## National Highways Planning Response (NHPR 22-12) Formal Recommendation to an Application for Planning Permission

**Council's Reference:** 2022/91477

**Location:** Land off Lindley Moor Road, Lindley, Huddersfield

**Proposal:** Hybrid Planning Application for the erection of an industrial unit for E(g)/B2 /B8 use with associated access, parking, groundworks and landscaping in conjunction with an outline application for mixed use development use class E(a), E(b), E(g), B2 and B8

REV	DATE	DESCRIPTION
PROJECT		
LINDLEY MOOR ROAD, LINDLEY MOOR		
TITLE		
DEVELOPMENT TRAFFIC (FIRST PRINCIPLES)		
SCALE		
NTS @ A3		
DRAWING		
2061 - 108		
DATE		
05.01.2023

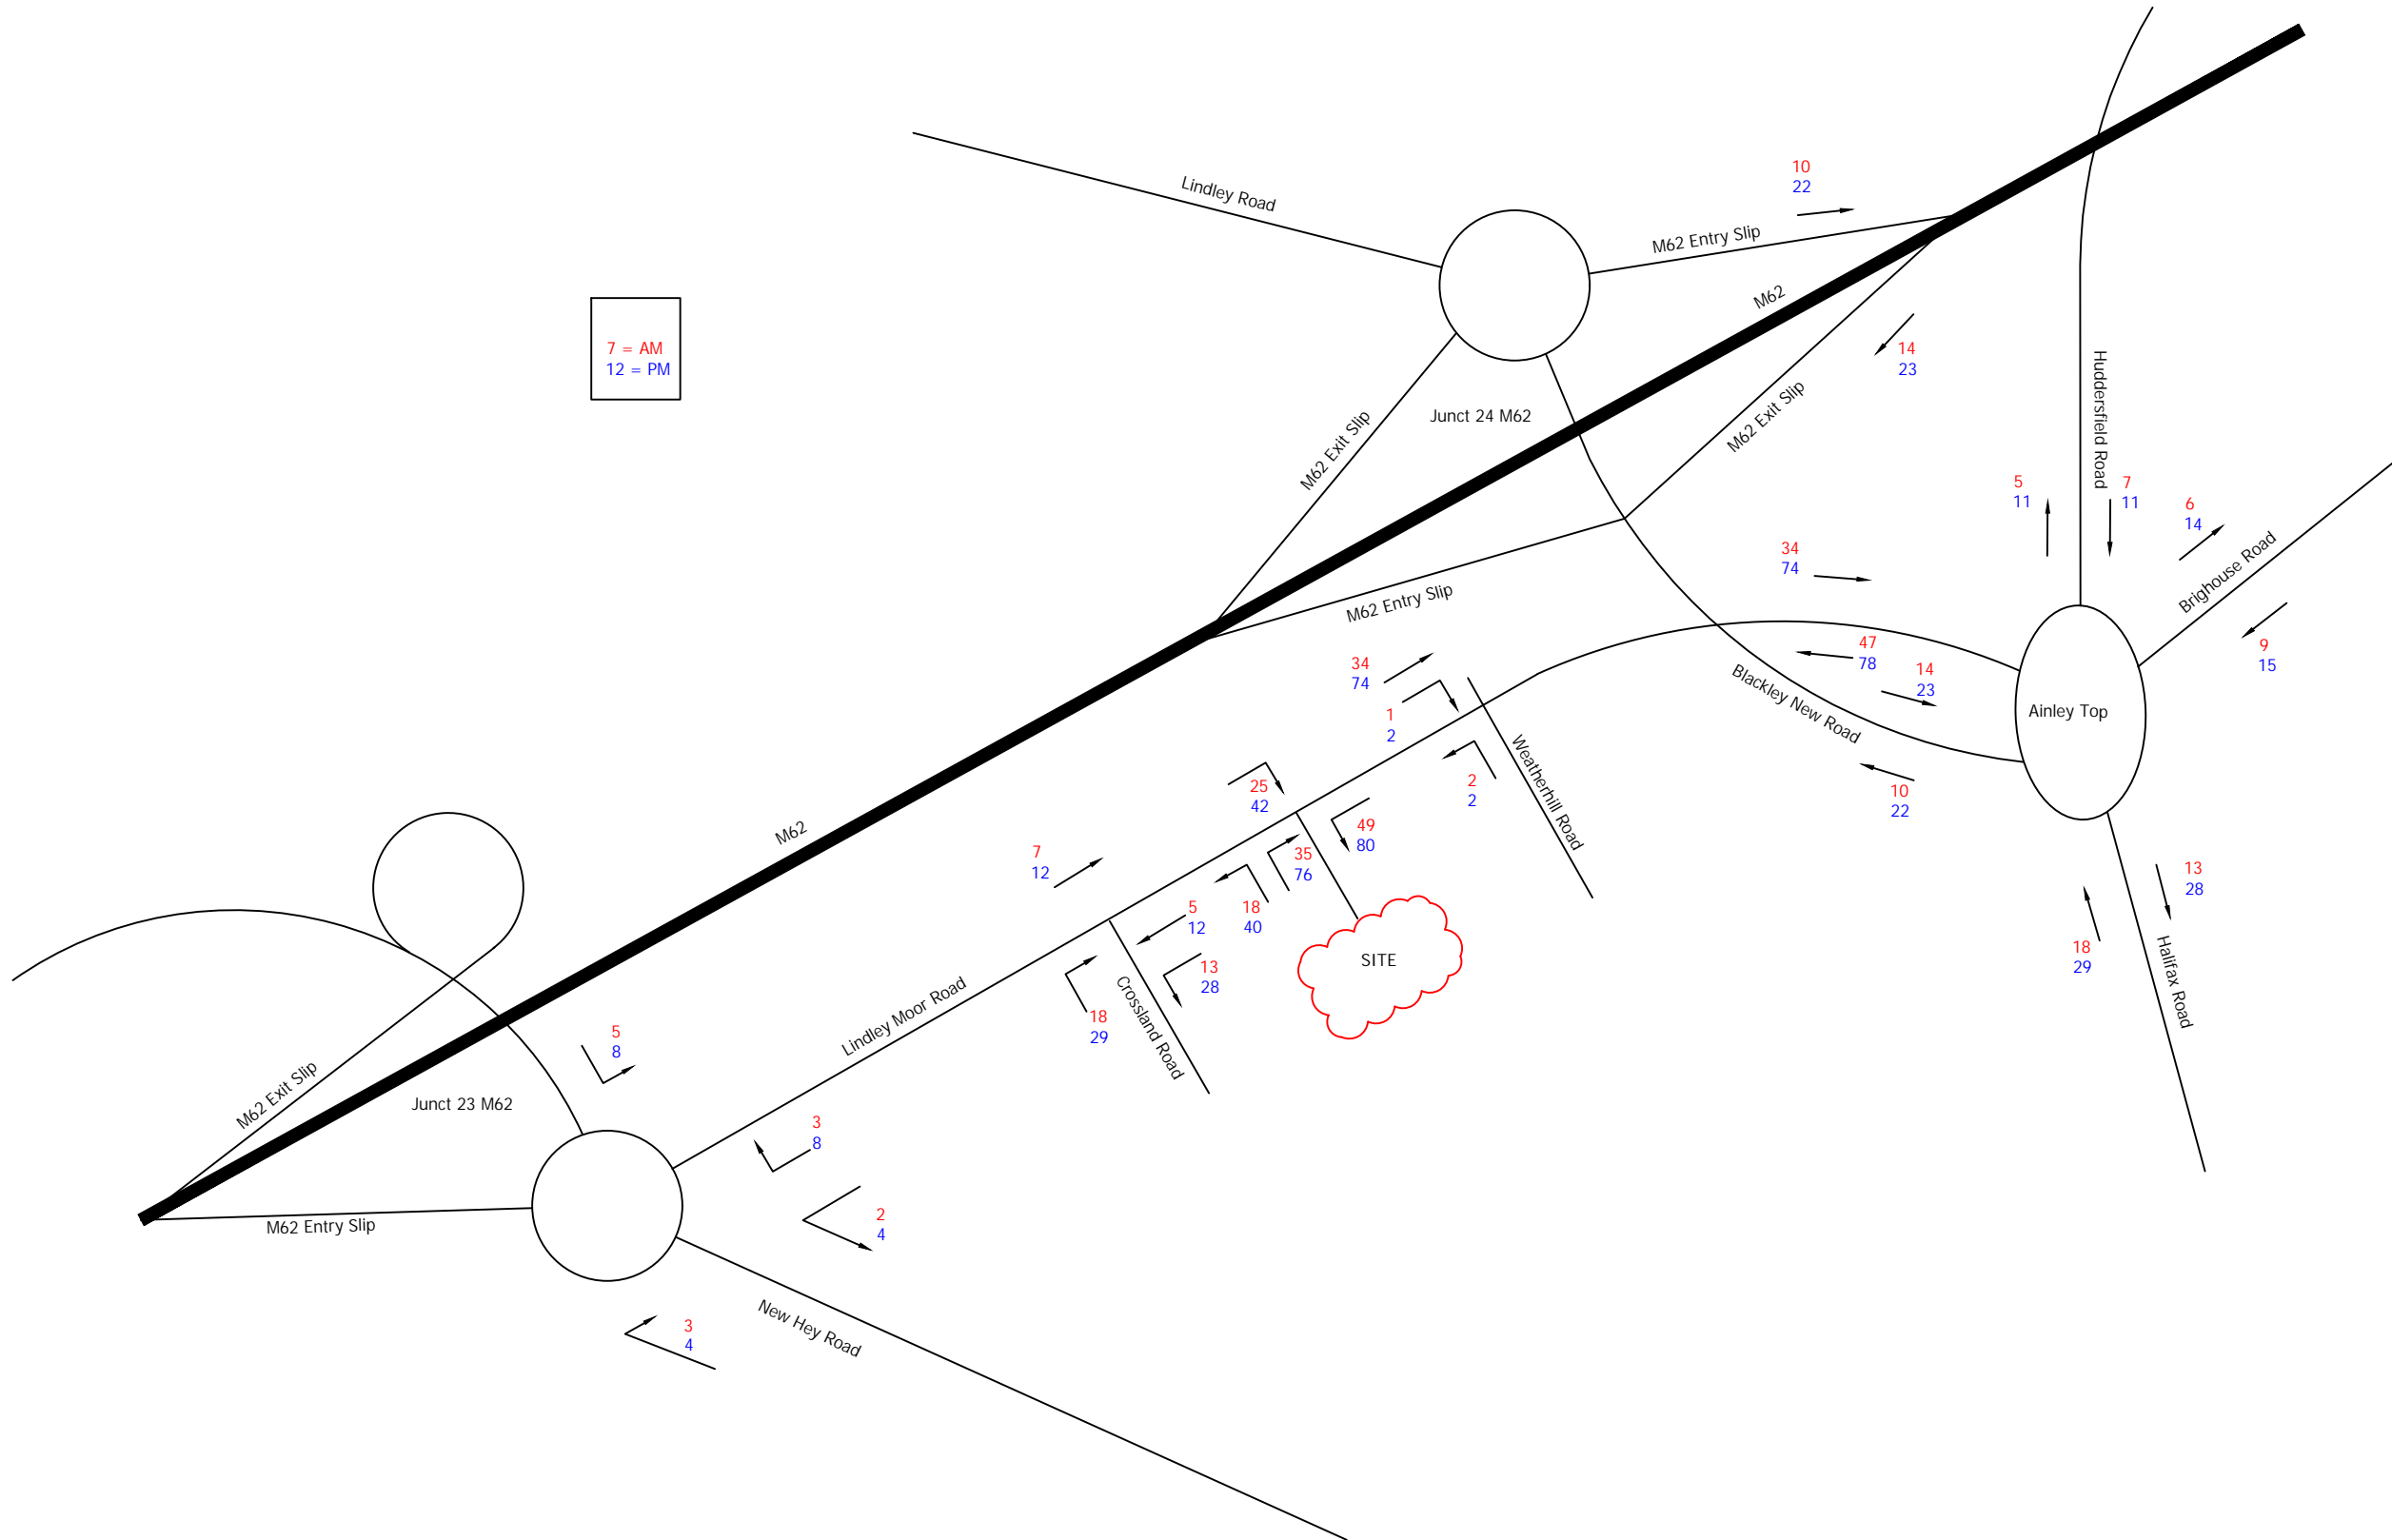
**JSJV Comment** – A traffic flow diagram has been produced by Paragon to demonstrate the flows generated by Unit P through the study area. This is welcomed by JSJV, as it shows the number of trips accessing the SRN – M62 Junction 24 – in the morning and evening peaks; namely 24 two-way trips in the morning peak and 45 two-way trips in the evening peak. Furthermore, there are 61 two-way trips in the morning peak and 101 two-way trips in the evening peak passing through the Ainley Top roundabout, as discussed above.

As such, JSJV do not agree with the conclusion reached by Paragon that the increase in flows is not significant, given the two-way flows stated alongside the JSJV consideration that a key issue in the operation of M62 Junction 24 relate to the operation of the local road network roundabout, causing queuing on Blackley New Road.
